Project # 7036 81st Ave SE, Mercer Island 98040

Correction Notice #1

Date: 12/10/20

Review Type: Fire, Land Use, Building, Civil, and Trees

**A001**

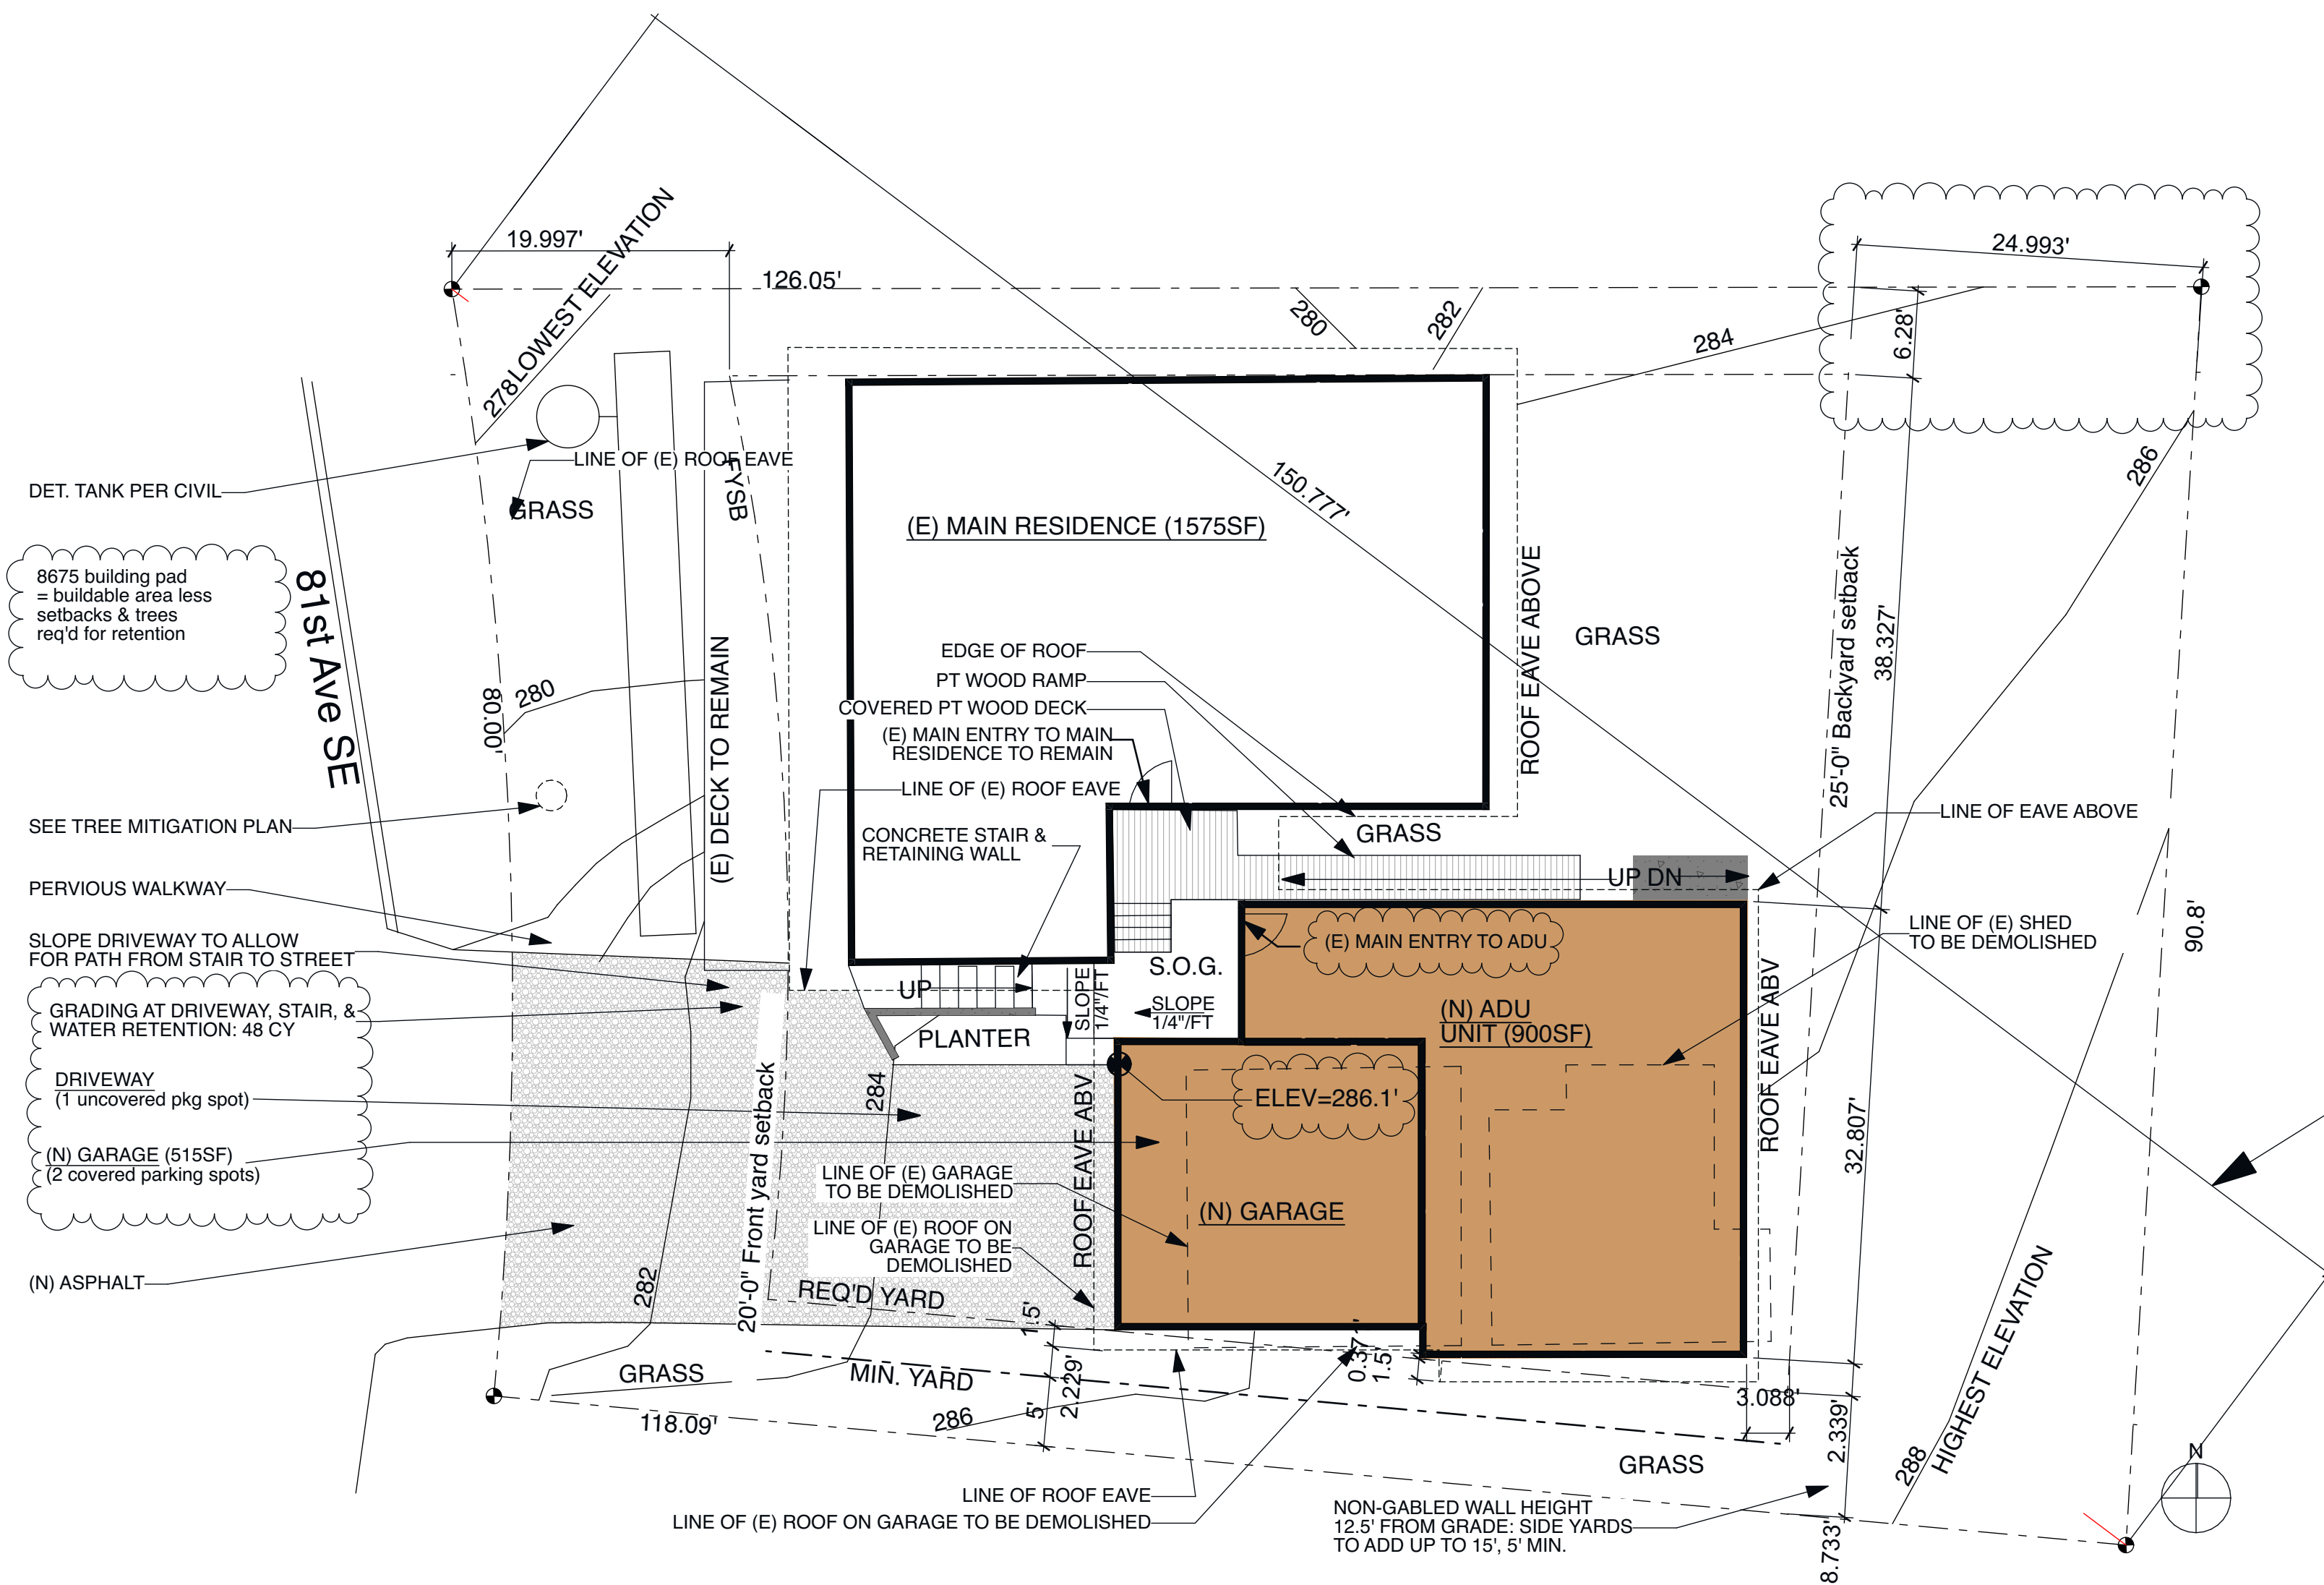
This project requires a 1" meter size and a 1.25" supply line

Monitored Household Fire Alarm per NFPA 72 required in both the main residence and the ADU

Indicate building pad area, the amount of covered and uncovered stalls, and any land use applications associated with this project/property

Need to apply for ADU application – refer to attachments. Please label the ADU Entrance on the site plan

Required yard setback dimensions need to be shown on the site plan

Minimum side yard setback dimensions need to be clearly labeled- no eave protrusion is allowed in the minimum side yard setback.

I let the owner and contractor know. I added a note pertaining to this on A001 (bubbled) as well.

I let the owner and contractor know, made a note on A001 and on all floor plans containing smoke detectors, A101 & A102. I've also uploaded the required documents approved by the fire marshal.

Please see A001 for the required information

Please see the uploaded application and please see the site plan on A001 for the entry callout.

Please see A001 for the missing rear yard setback dimension

Please see the site plan A001 for the dimensions. I have both the required yard and the minimum yard shown. I also show that the eaves protrude into the required yard by 18", not the minimum yard. Eaves are allowed to protrude into the required yard per:

**A002**

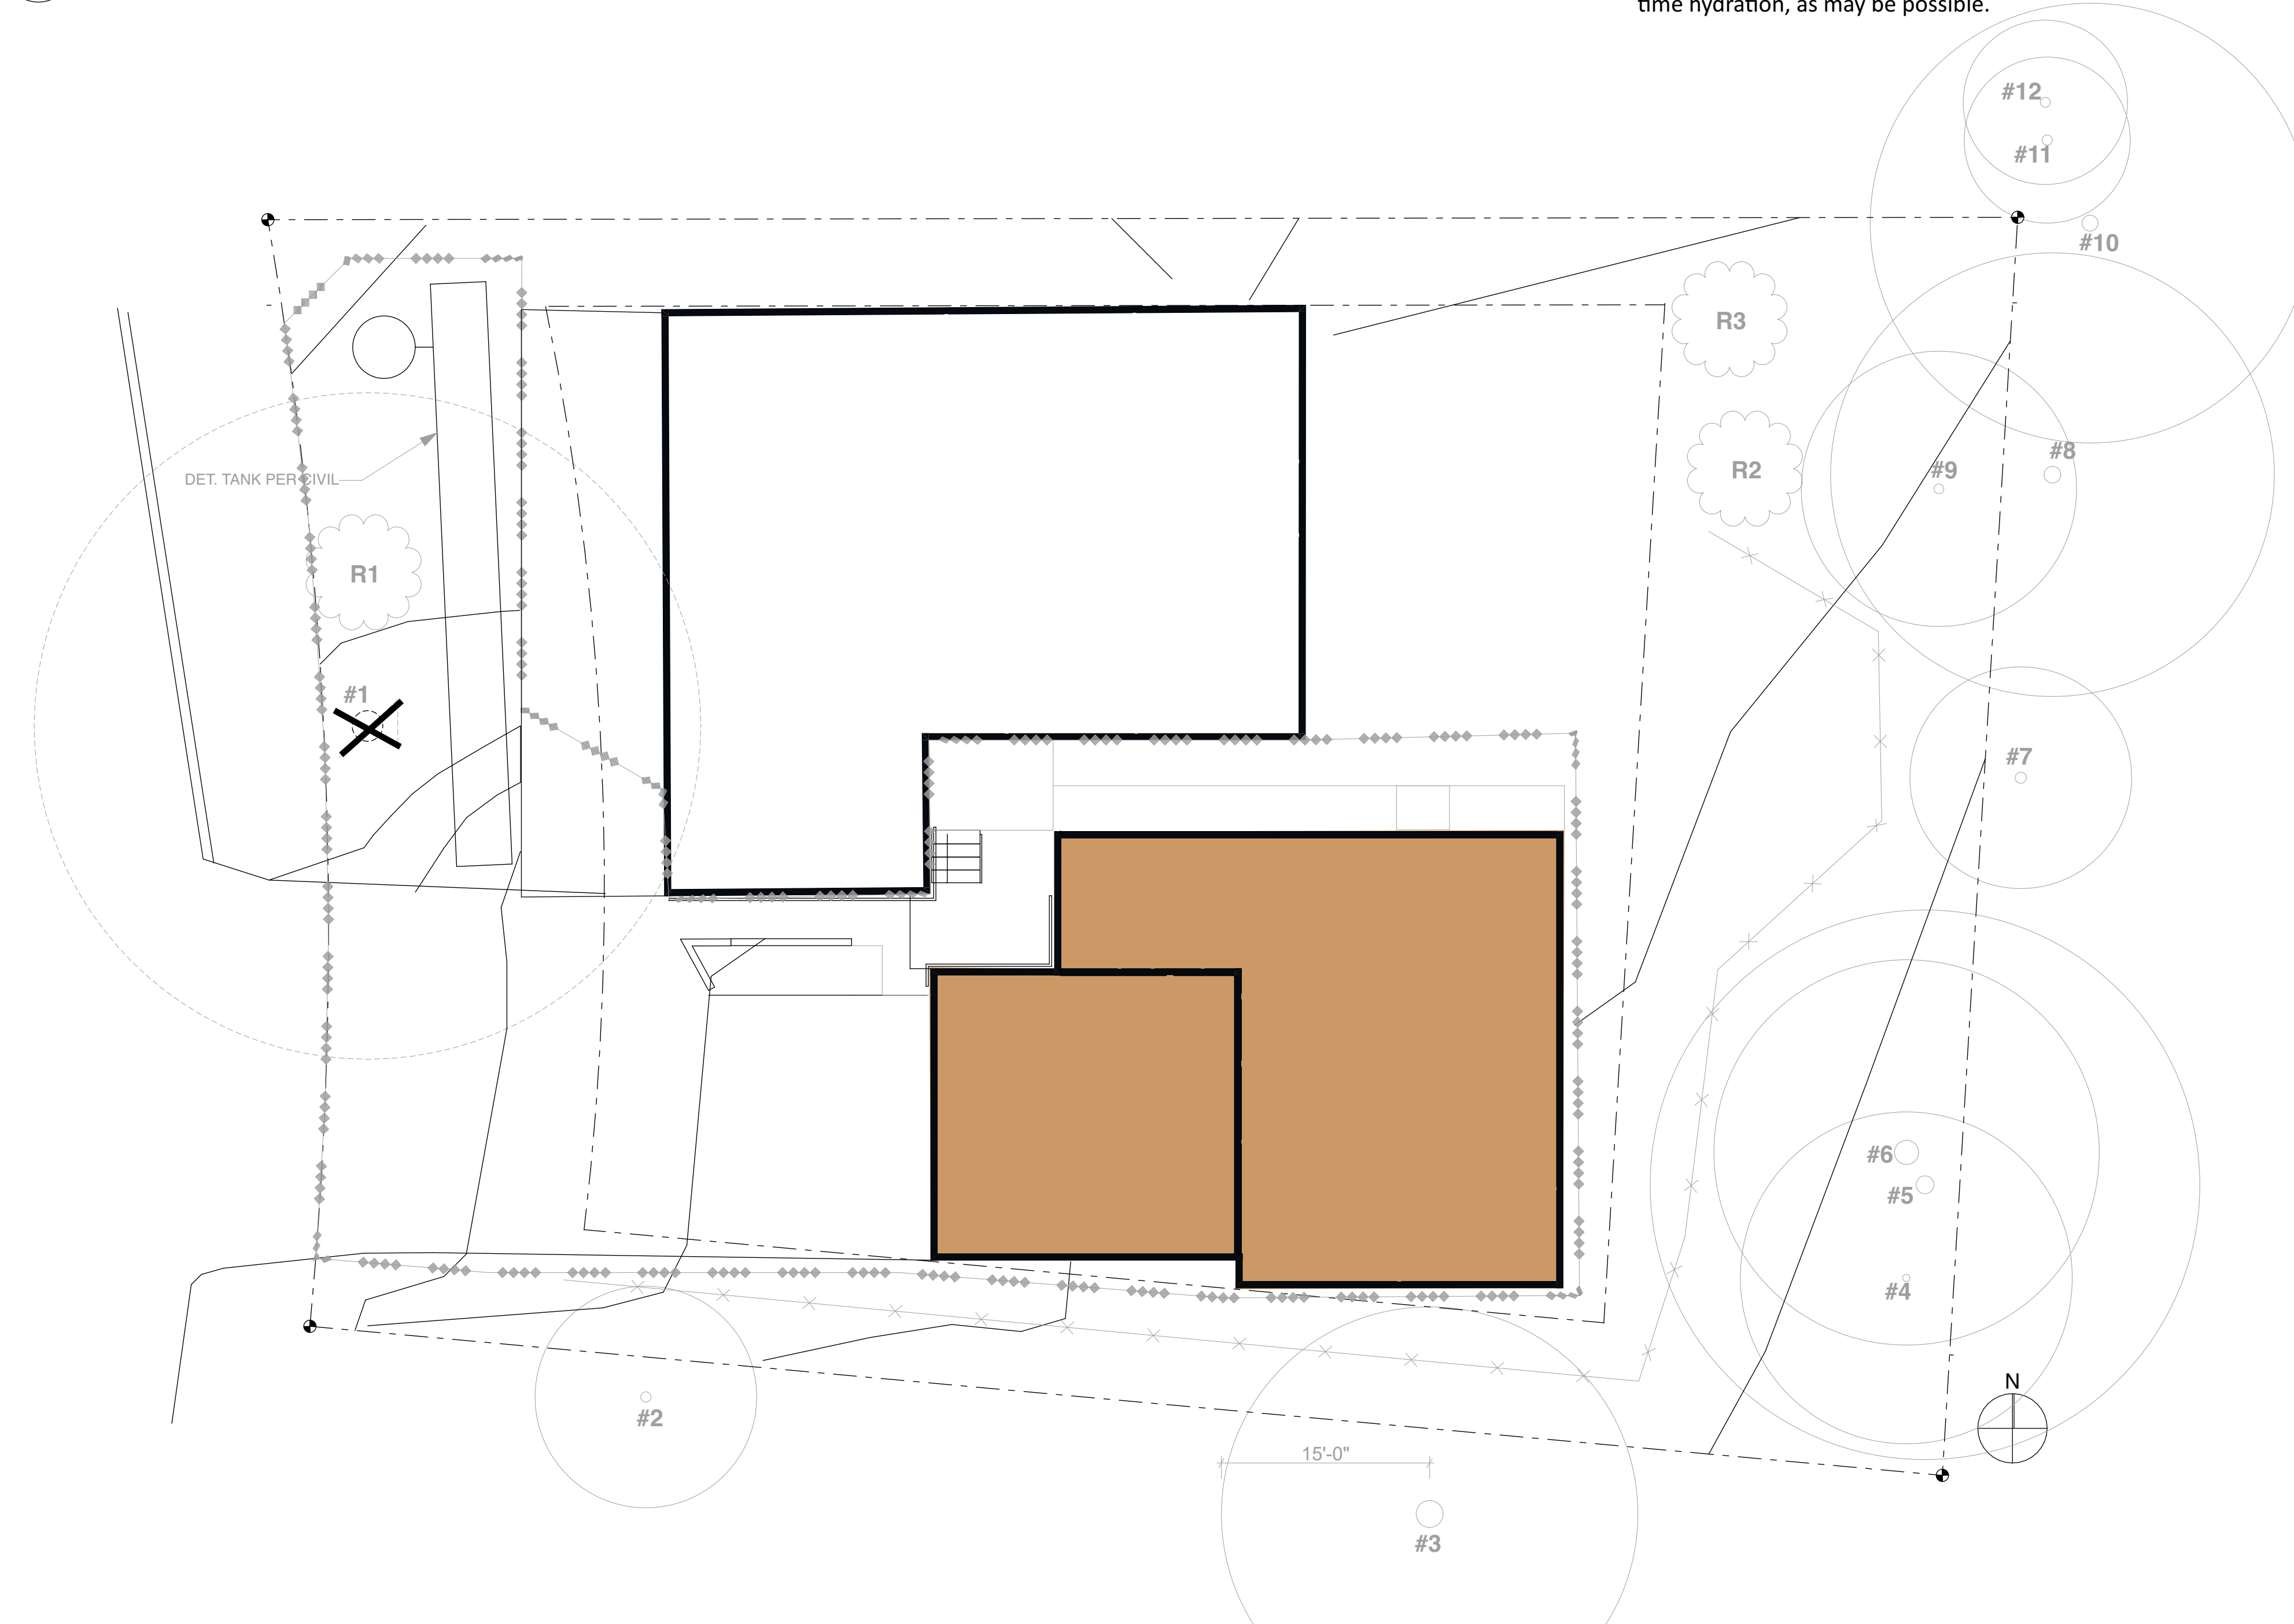
Provide a arborist report, tree inventory, and site/tree retention plan

Please see A002 for this information along with the report provided by the arborist uploaded as a separate document
